Waste Services Consultation Response

Waste Management Officer		Head of Eng. Services	X	Refuse & Recycling Manager	
Description:	Old Garage site at Dunsop Bridge				 <p style="margin: 0;">Ribble Valley Borough Council</p> <p style="margin: 0; font-size: small;">www.ribblevalley.gov.uk</p>
Application Ref:	3/2022/082	Case Officer:	JM		
Response Ref:	AH/52	Issue Date:	030222

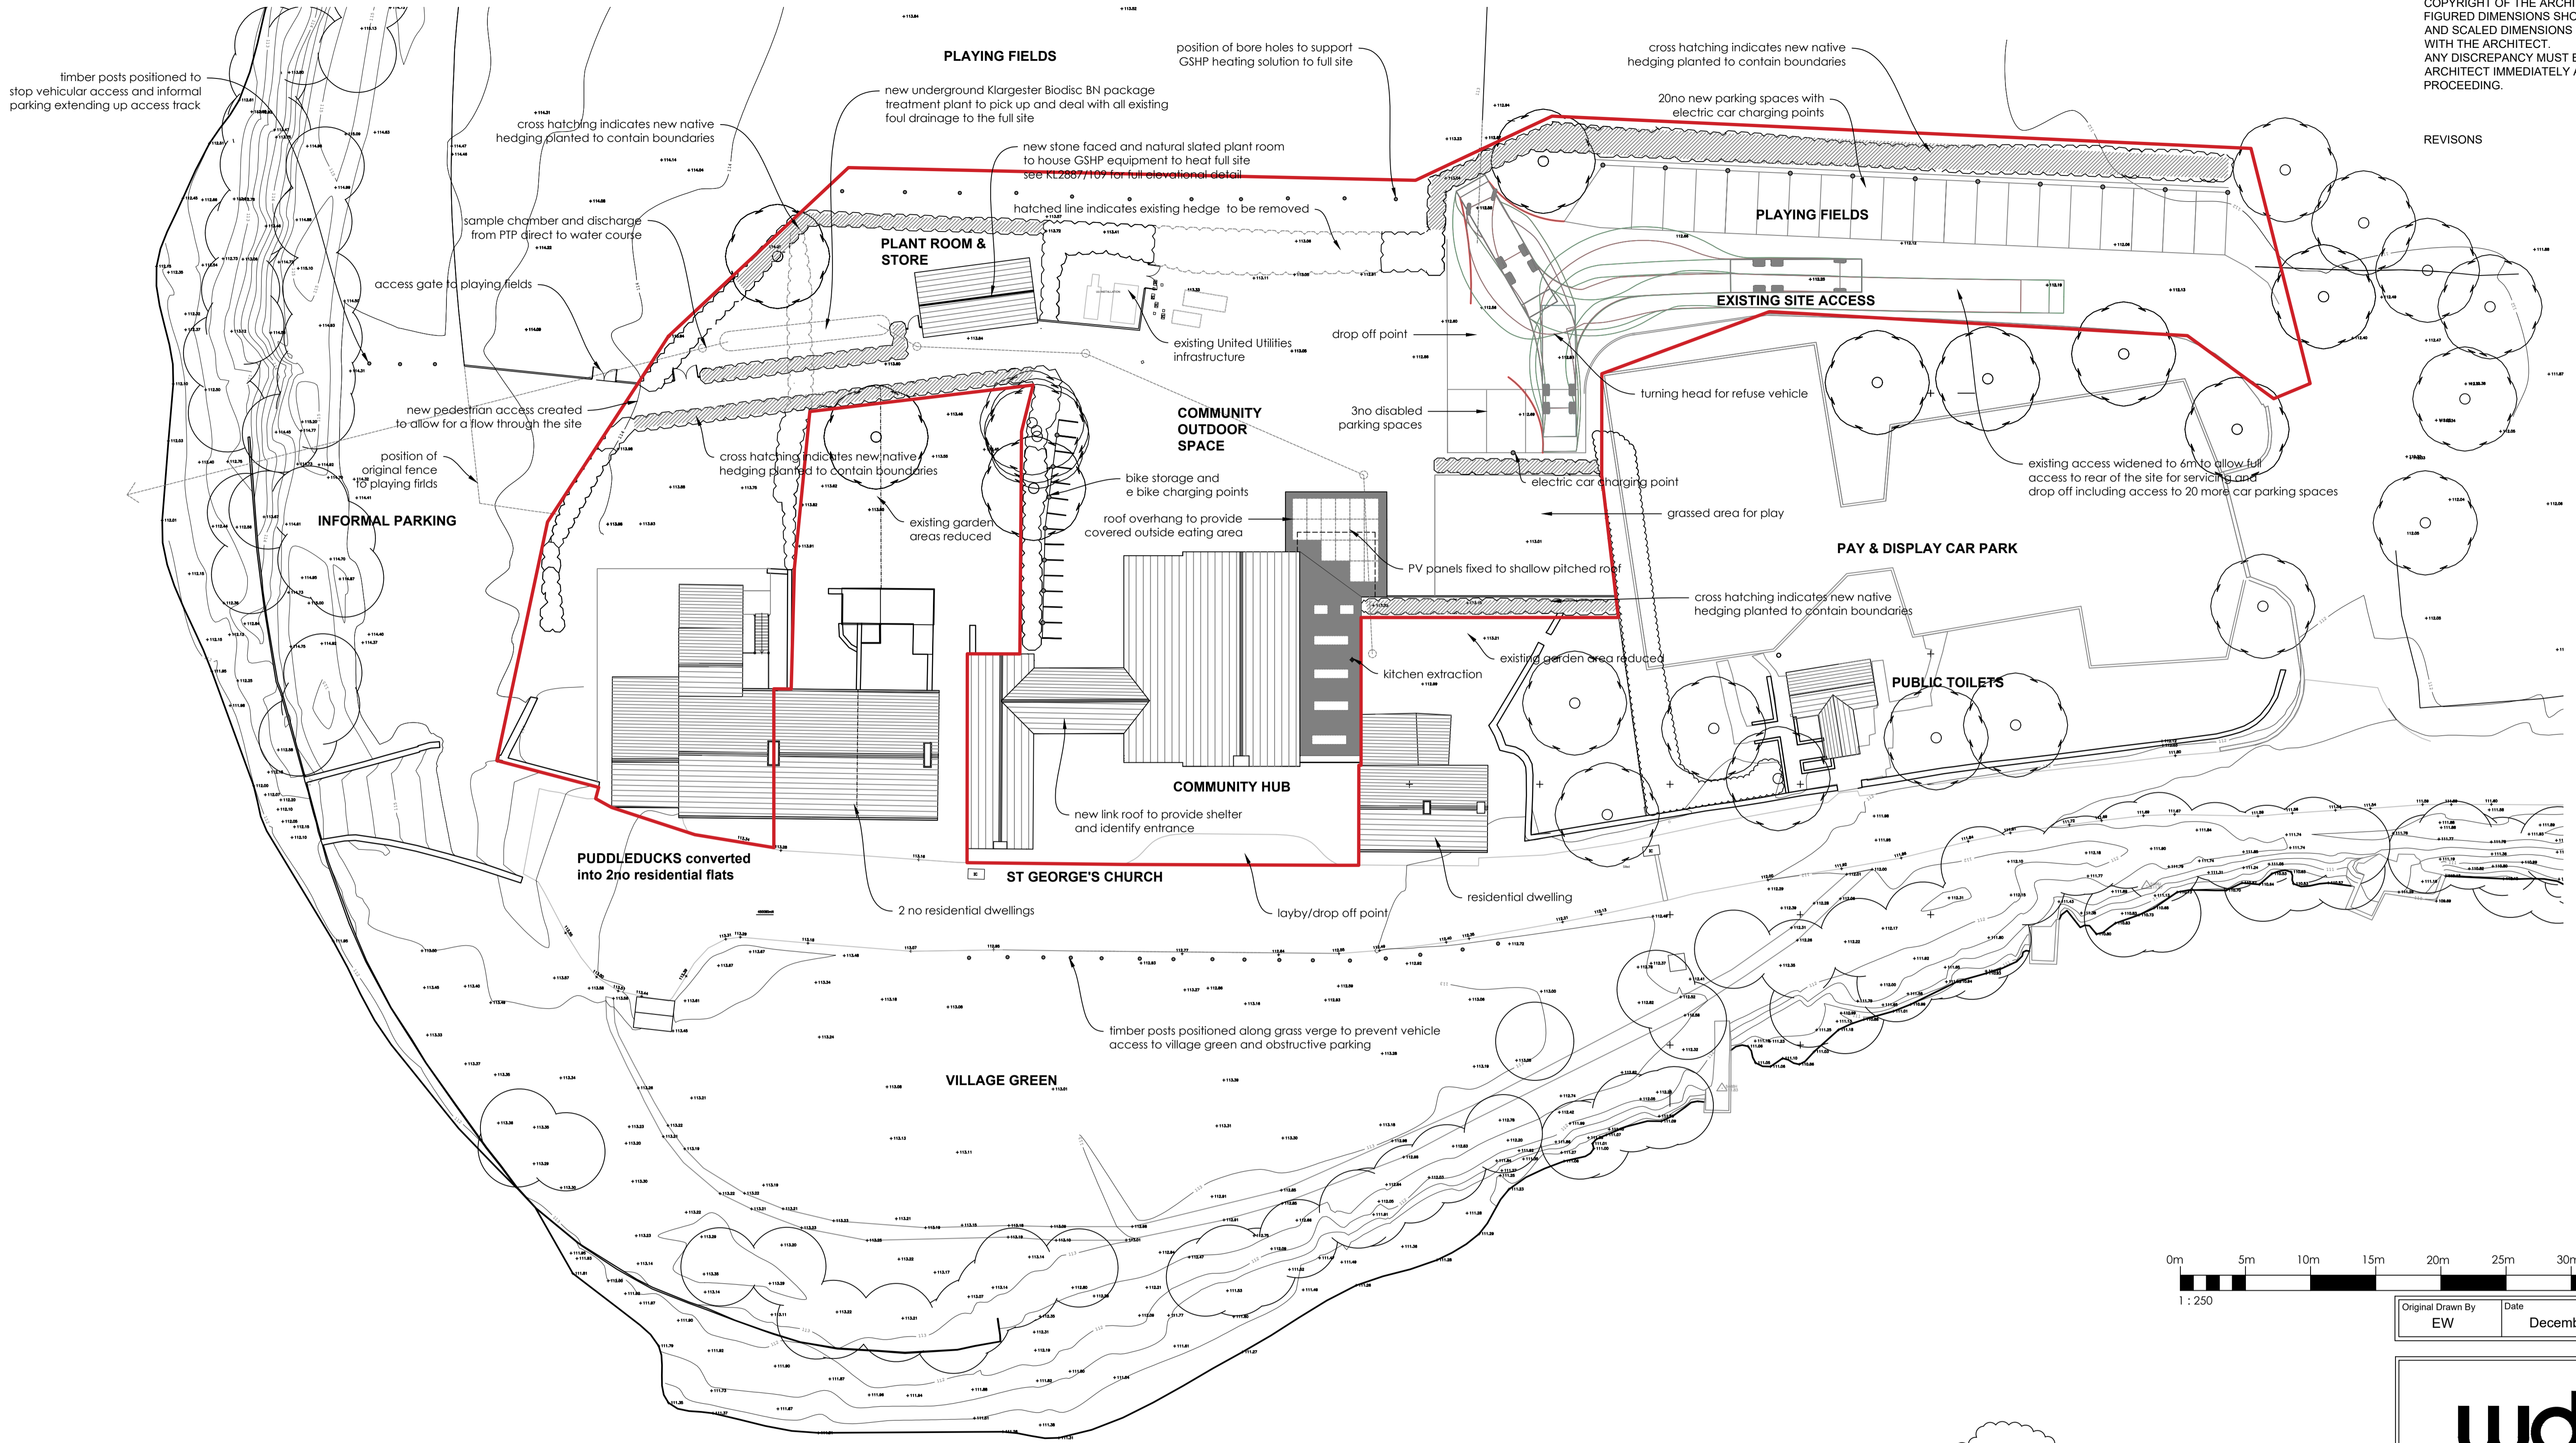
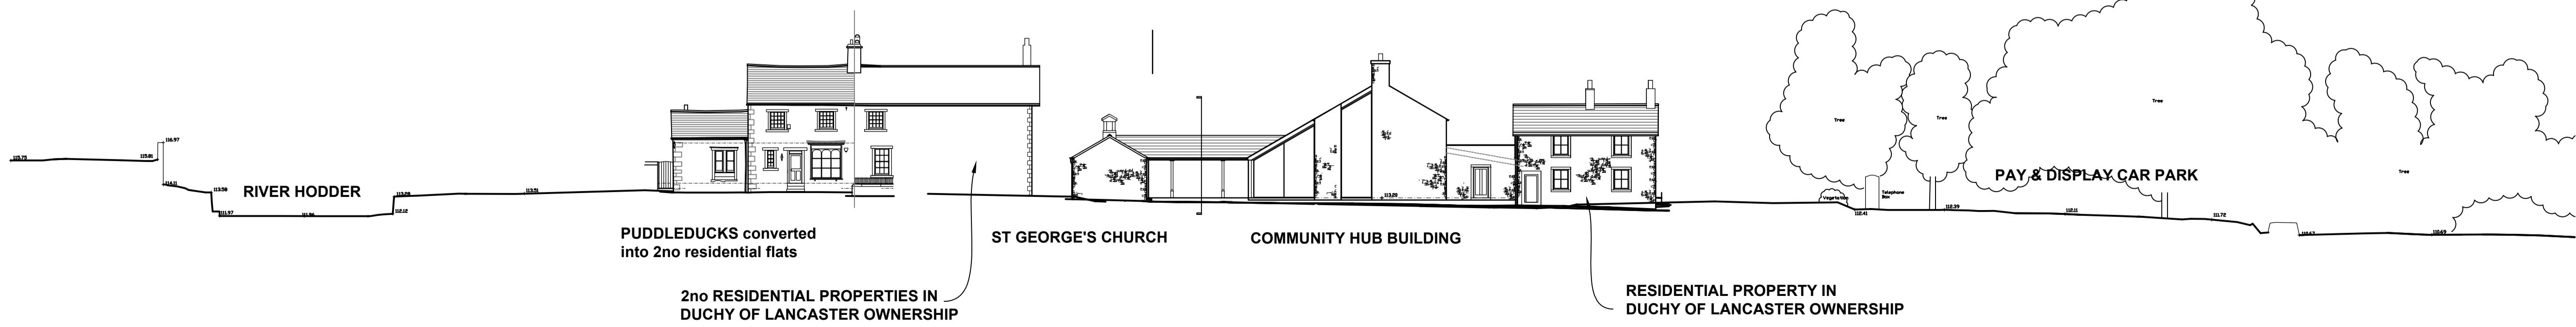
Comments/Observations:						
1.1 Access	Acceptable:	Yes	x	No		
Access to the site appears to be reasonable						
2.1 Manoeuvrability	Acceptable:	Yes		No	x	
Turning head for refuse truck appears to rely on one of the disabled bays being vacant.

3.1 Collection/Storage Provision:	Acceptable:	Yes		No	x	
Can't see where there is a bin store for the community hub/café/retail unit or indeed where the 2 new flats will leave the bins

4.1 Additional Observations						
Presumably the existing car park and the new car park will be designed to take the weight of the refuse truck						
5.1 Conclusions/Suggested Conditions:
